Designers Response

- 1.1 This Designers Response has been prepared in respect of a Stage 1 Road Safety Audit (July 2018) which considers the access arrangements for the proposed residential development at Clays Farm, North End Road, Yapton, Sussex.
- 1.2 This Designers Response uses the paragraph numbering from the Stage 1 RSA for ease of reference.
- 1.3 The proposals consist of the provision of 33 residential dwellings, the existing Clays Farm access will be used to facilitate access to the development. The access will be a shared use.

Proposed Access Arrangements – Clays Farm

FIGURE 4.1

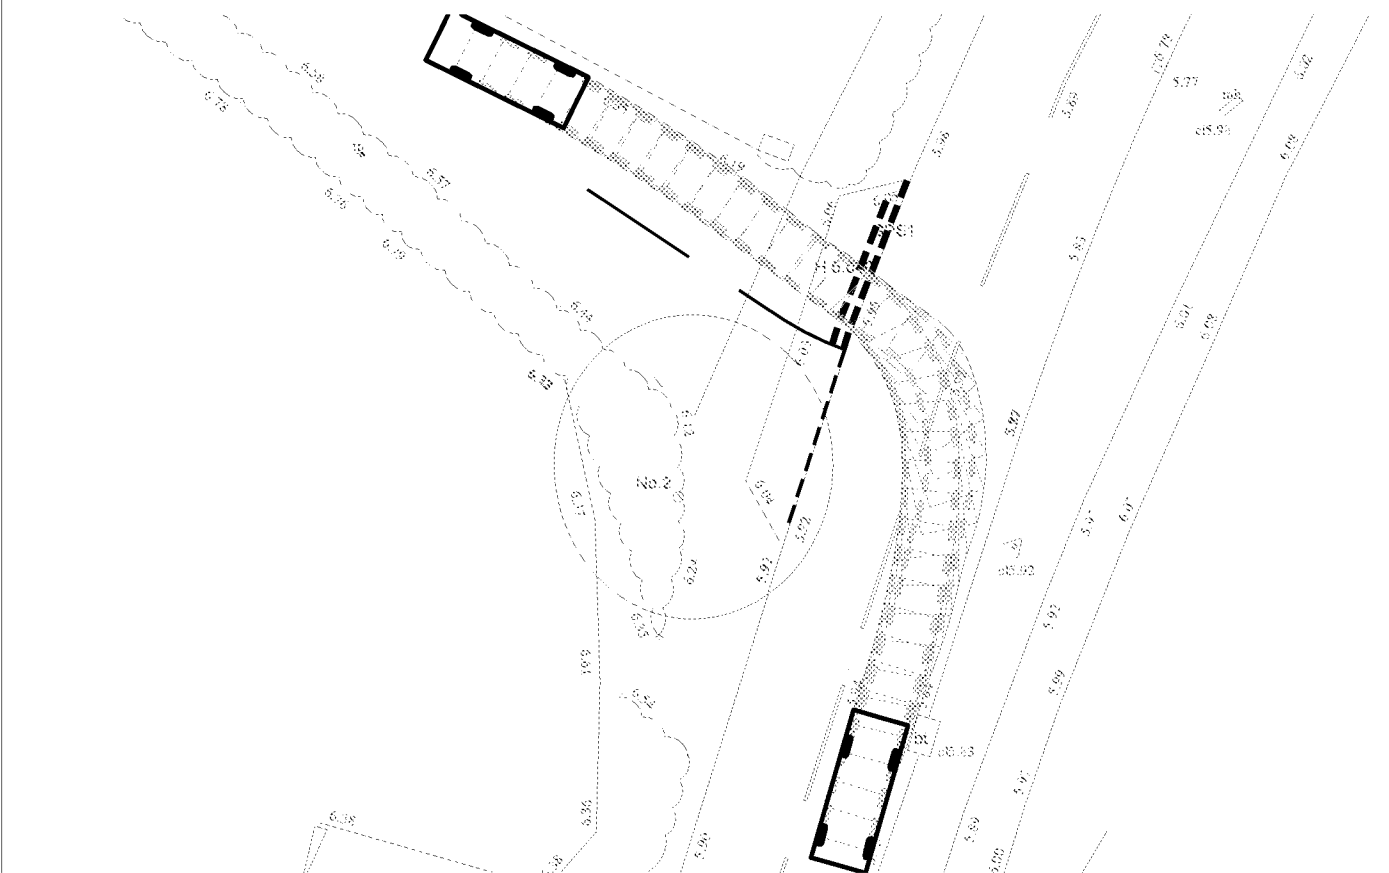
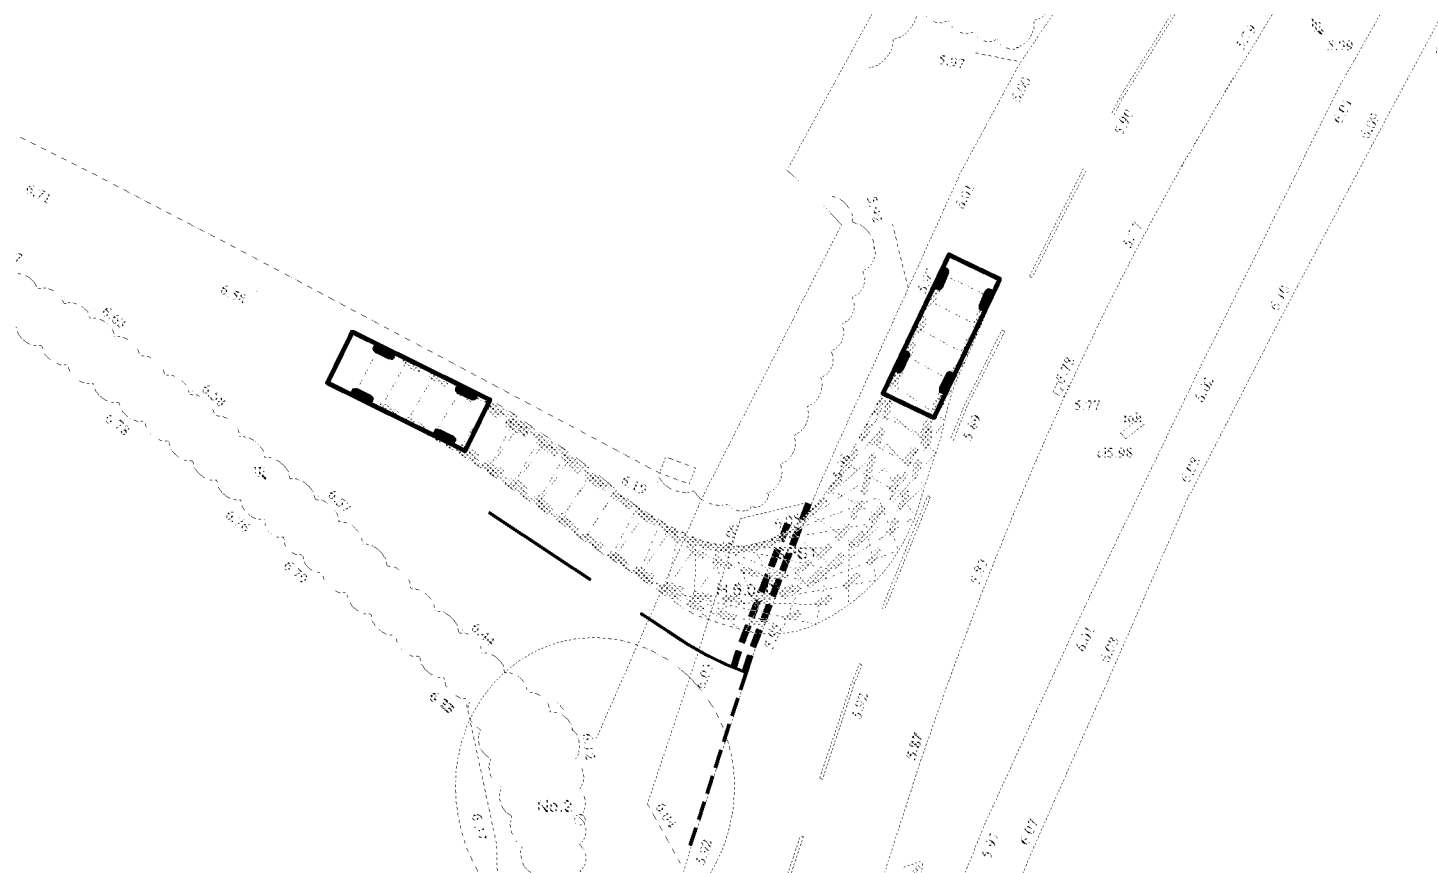
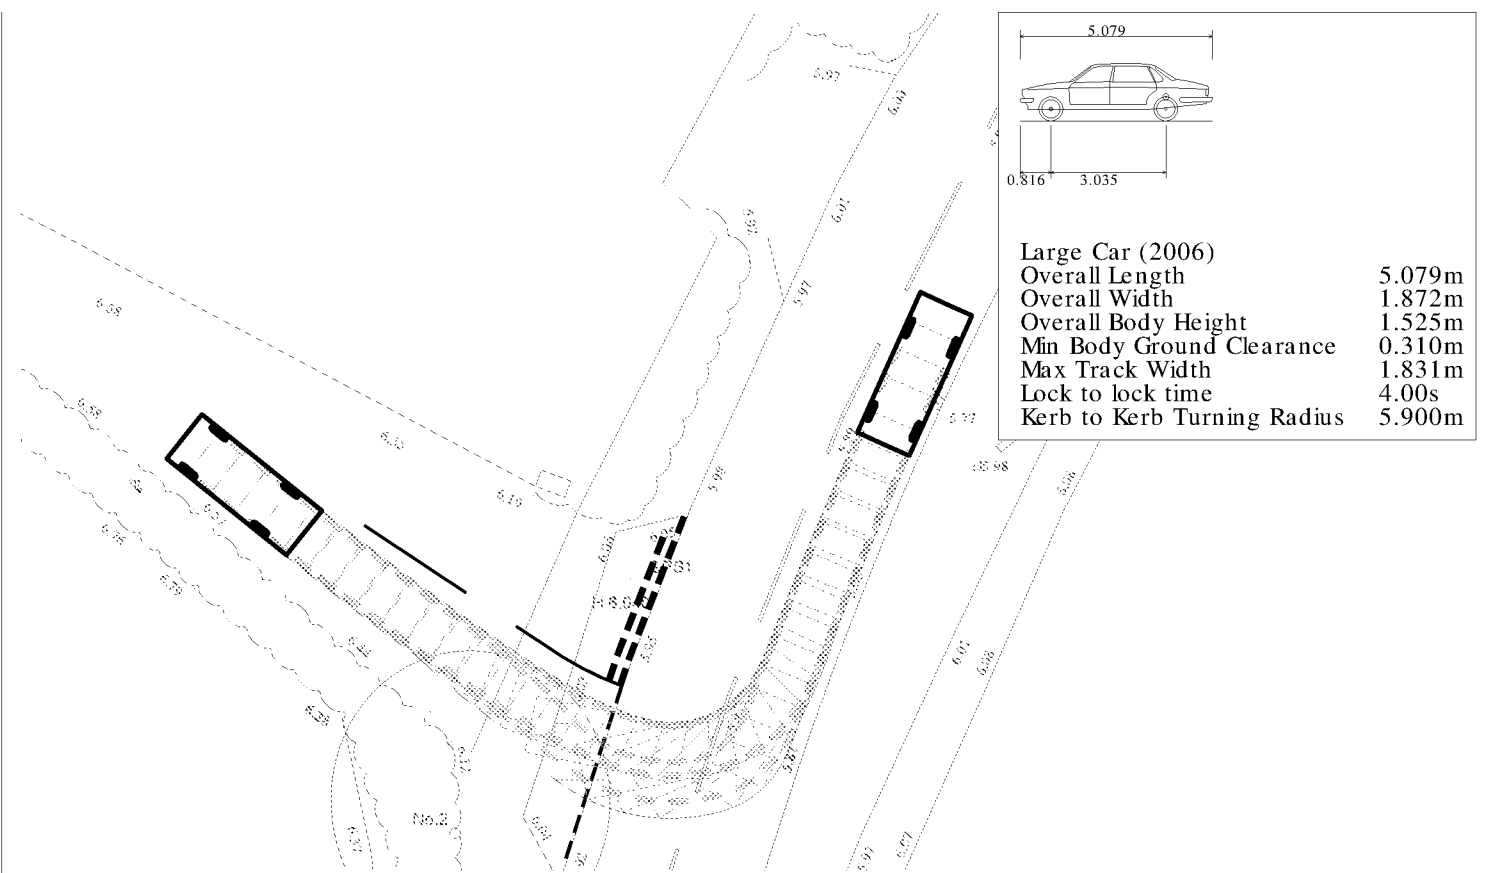
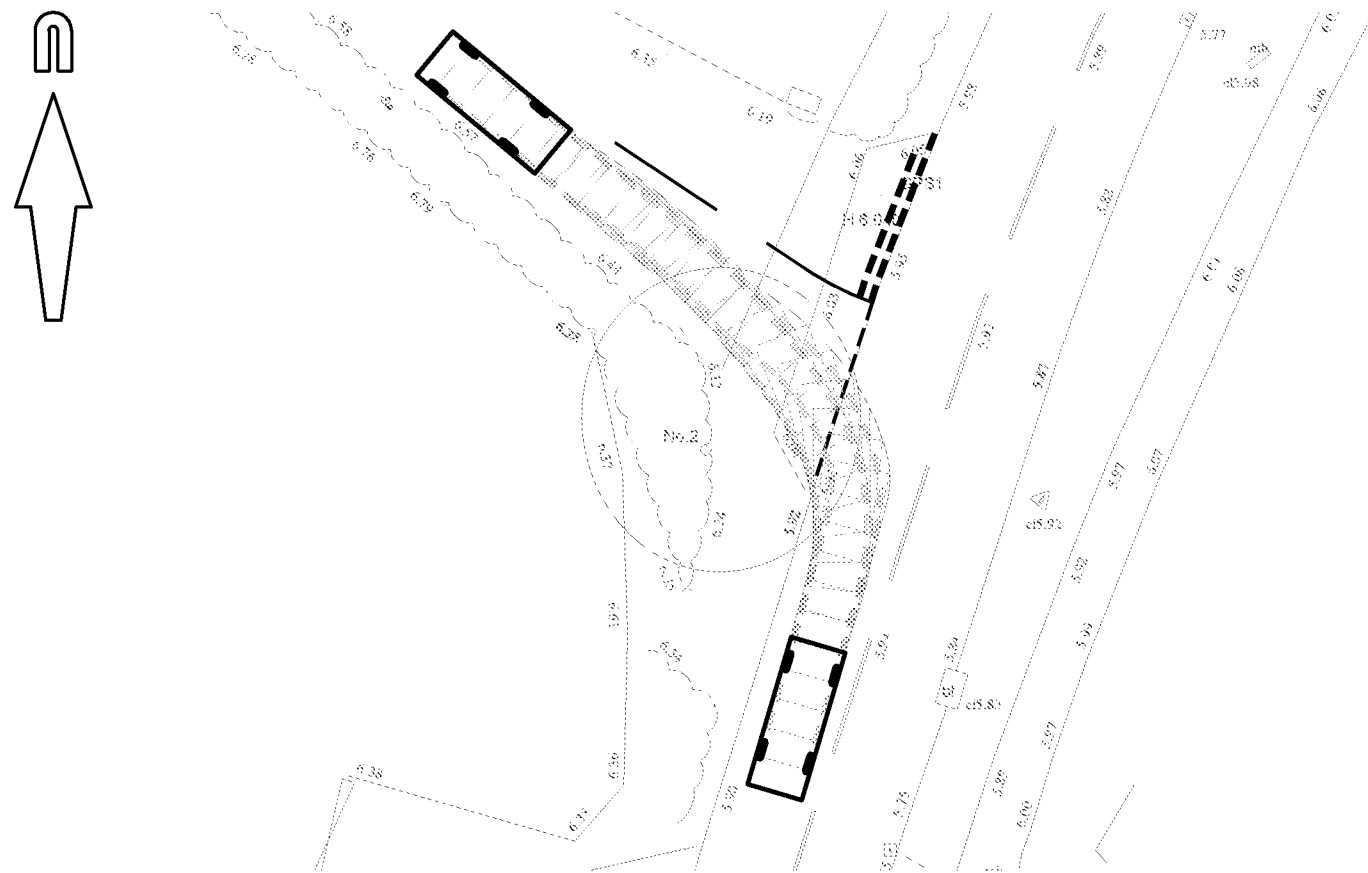
Problem 2.4 – Visibility

- 1.10 As identified by the Auditors, it is important to maintain the visibility splays for any access.
- 1.11 This matter is accepted by the designers and it is considered a suitable condition can secure such a provision.

FIGURE 4.7

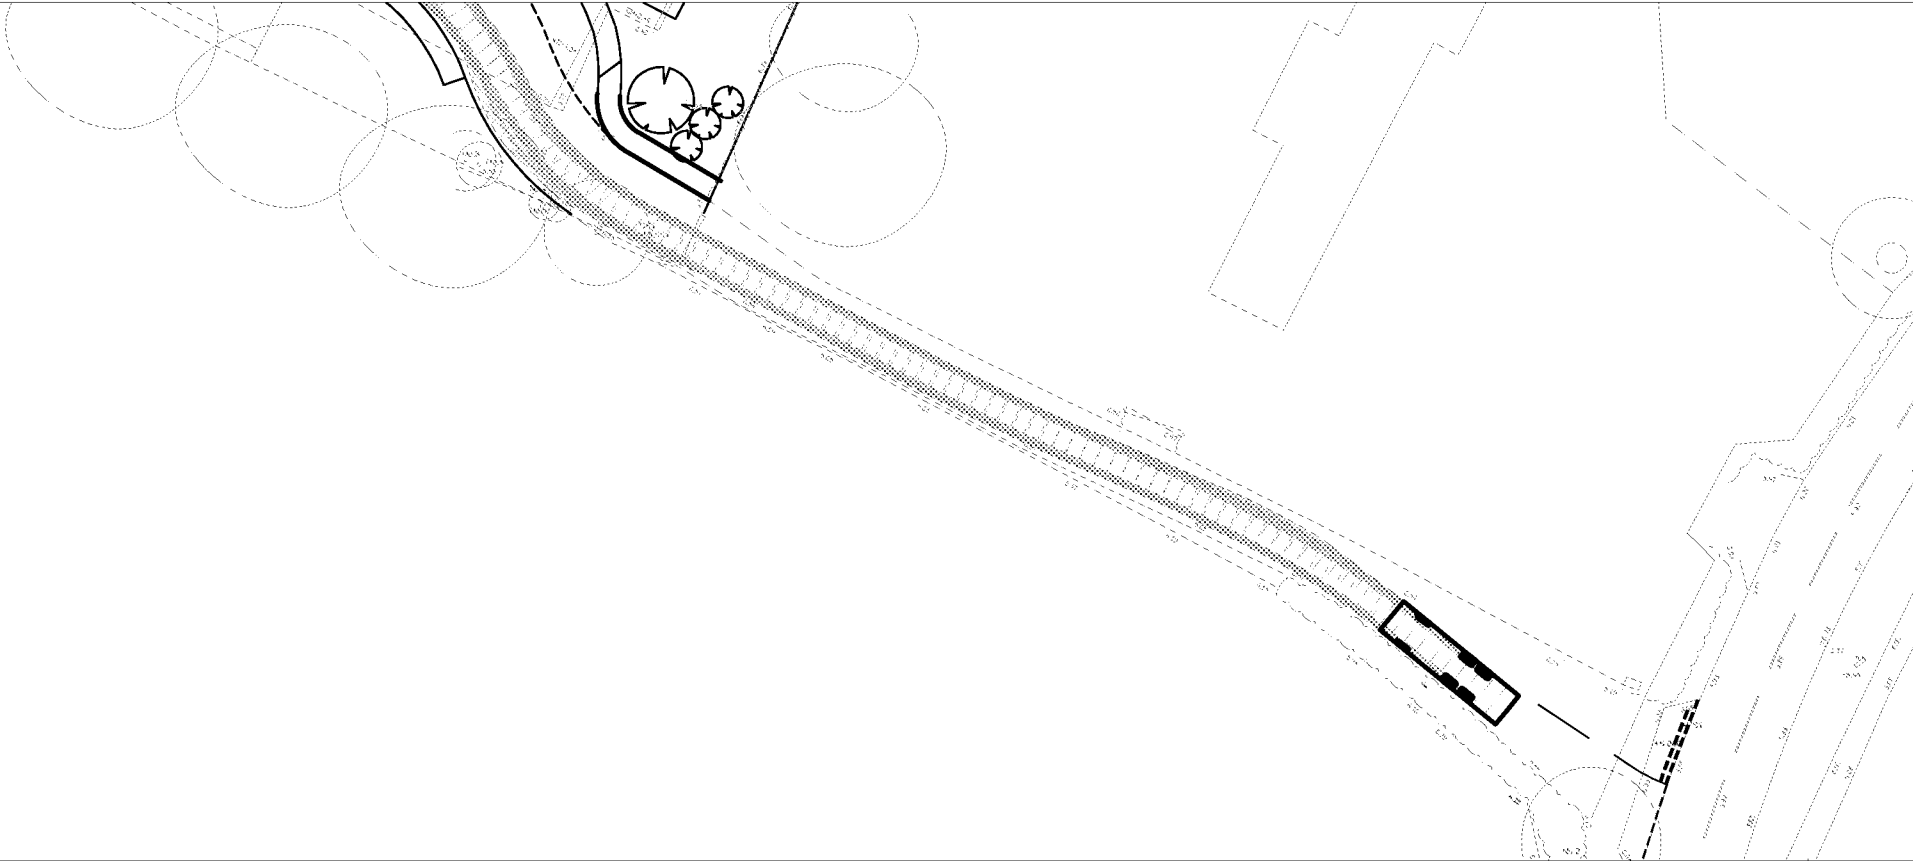
Problem 2.5 – Servicing Arrangements

- 1.12 As identified by the Auditors, it is important that swept paths be provided.
- 1.13 This matter is accepted by the designers and swept path analysis of vehicles likely to access to the site has been appended to the Transport Statement.
